Recommendation Report for Planning Permission for Works or Extension to a Dwelling

REF NO: AB/106/18/HH

LOCATION: 42 Fitzalan Road
Arundel
BN18 9JS

PROPOSAL: Dormer extension to front first floor.

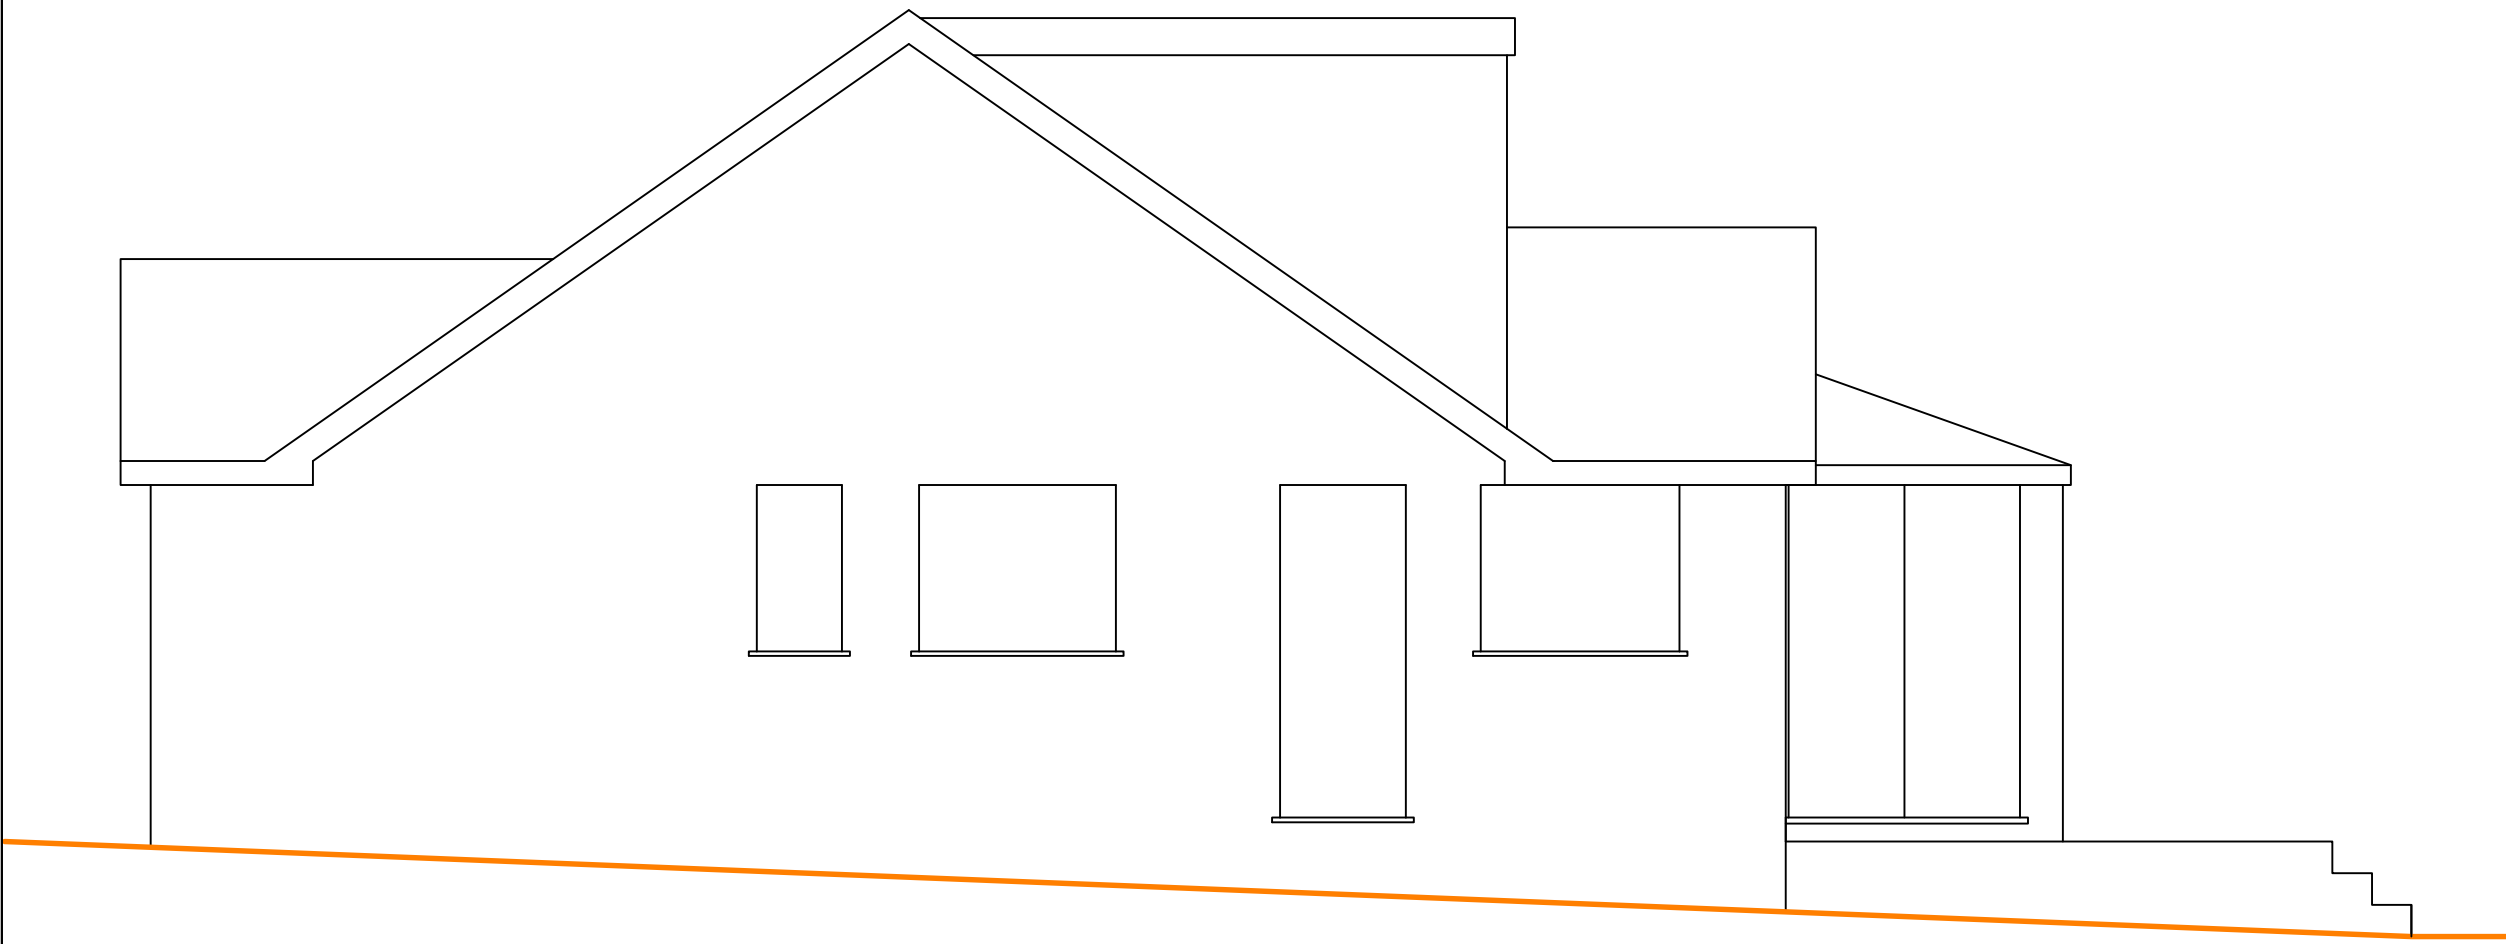
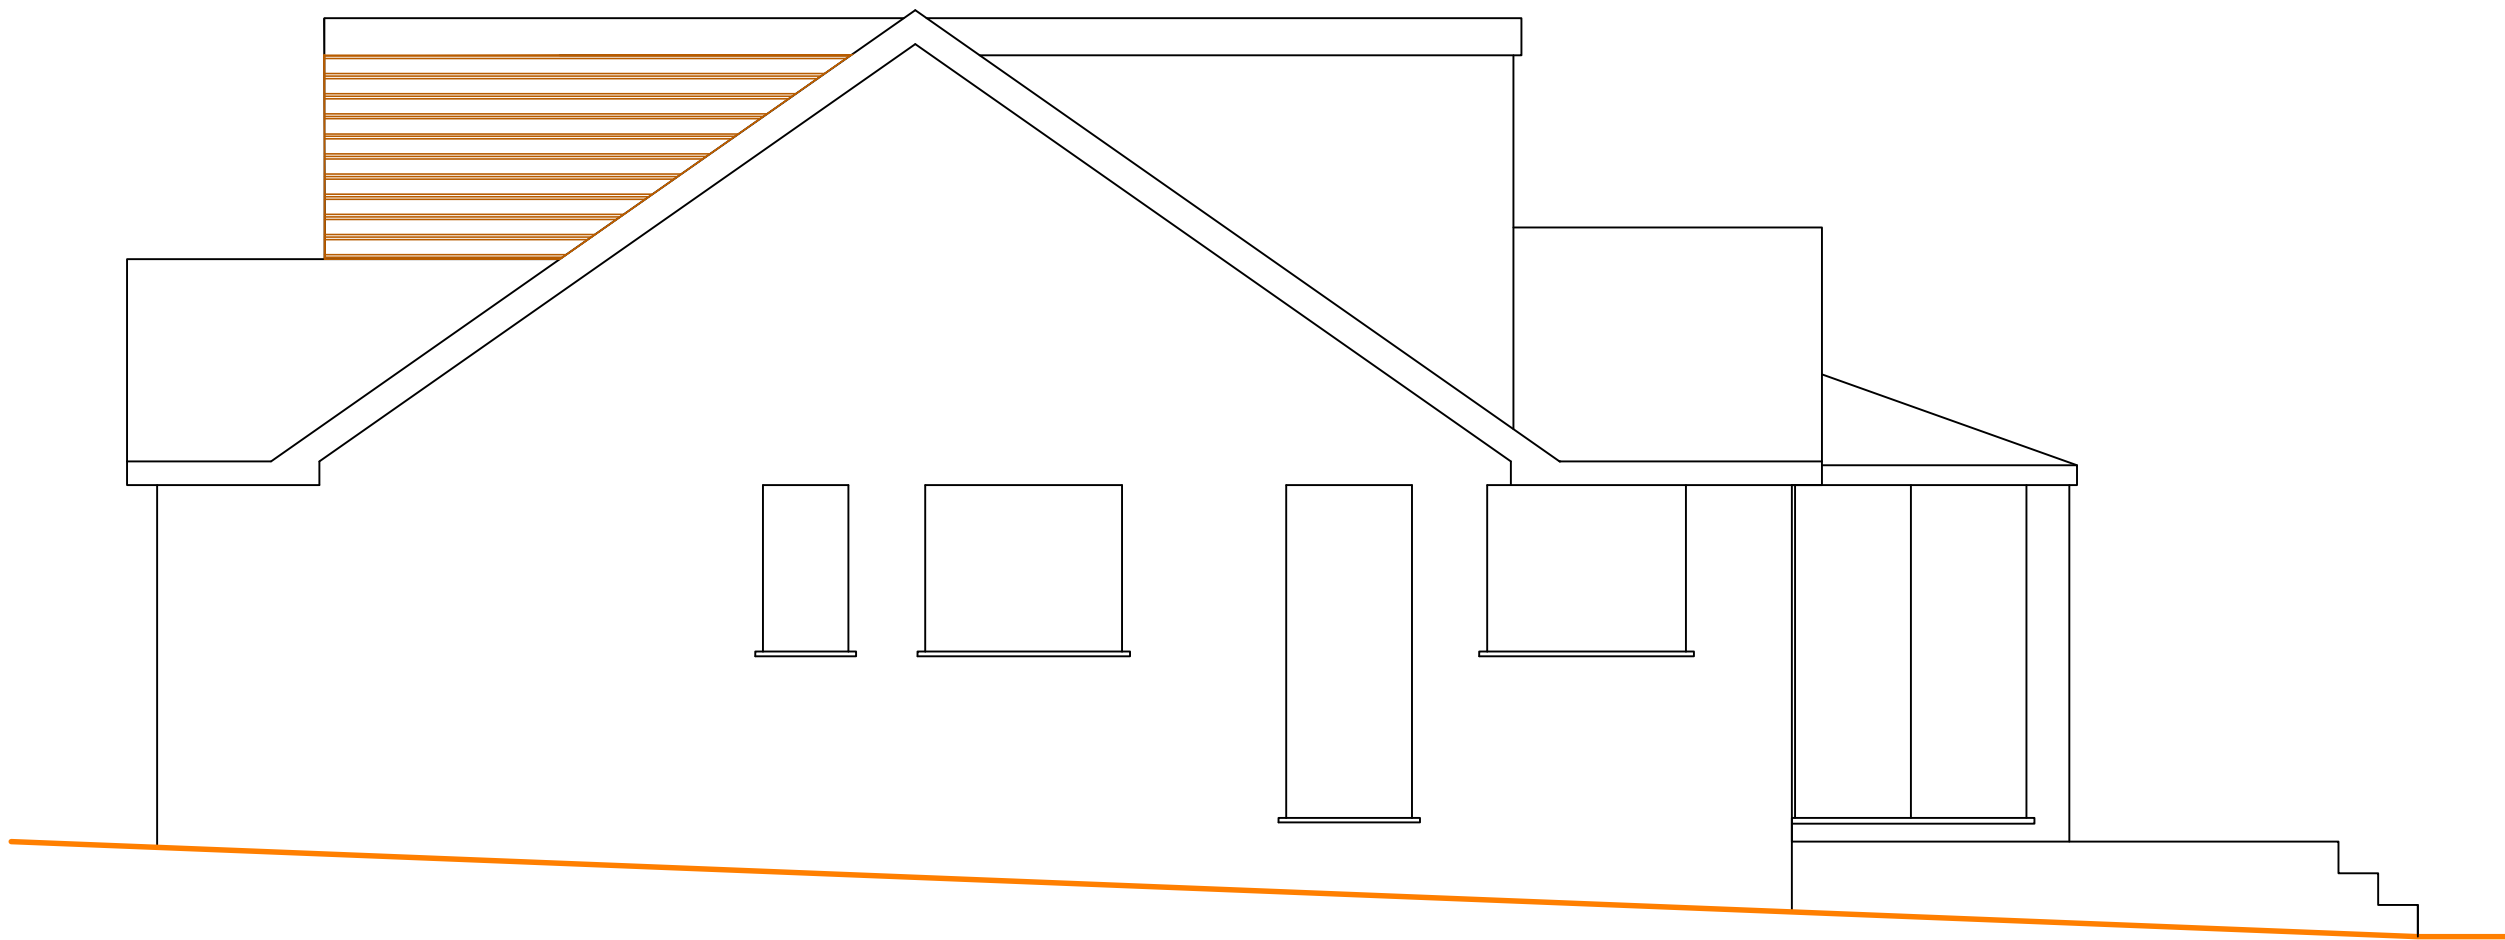
Due to the position of the proposed development, it will be visible from the street scene, however, the proposal is not deemed to have an unacceptably adverse impact on the established spatial pattern of the area. This is because the proposal does not extend beyond the Northern end of the room, and retains within the same footprint as the existing dwelling. As a result of this, the proposed development is considered to be in accordance with D DM4(e) of the Arun Local Plan.

The proposed development is considered to appear subservient to, and well integrated with the host dwelling, this is as a result of the extension matching the ridge height of the host dwelling and the existing rear dormer. Additionally, the property to the South of the application site has a similar development with similar siting, as such, it is considered that the proposal is in accordance with D DM1, D DM4(a) and (b) of the Arun Local Plan.

The proposal is not deemed to have a significant overshadowing or overbearing impact on adjacent properties, due to its relatively modest scale and siting on the host dwelling. Whilst it is noted, that the proposed development features additional windows, these are on the front elevation facing the street scene, and as such, are not considered to result in any significant loss of privacy at adjacent dwellings. Resultantly, it is considered that the proposal is in keeping with D DM1(3) and D DM4(c) of the Arun Local Plan.
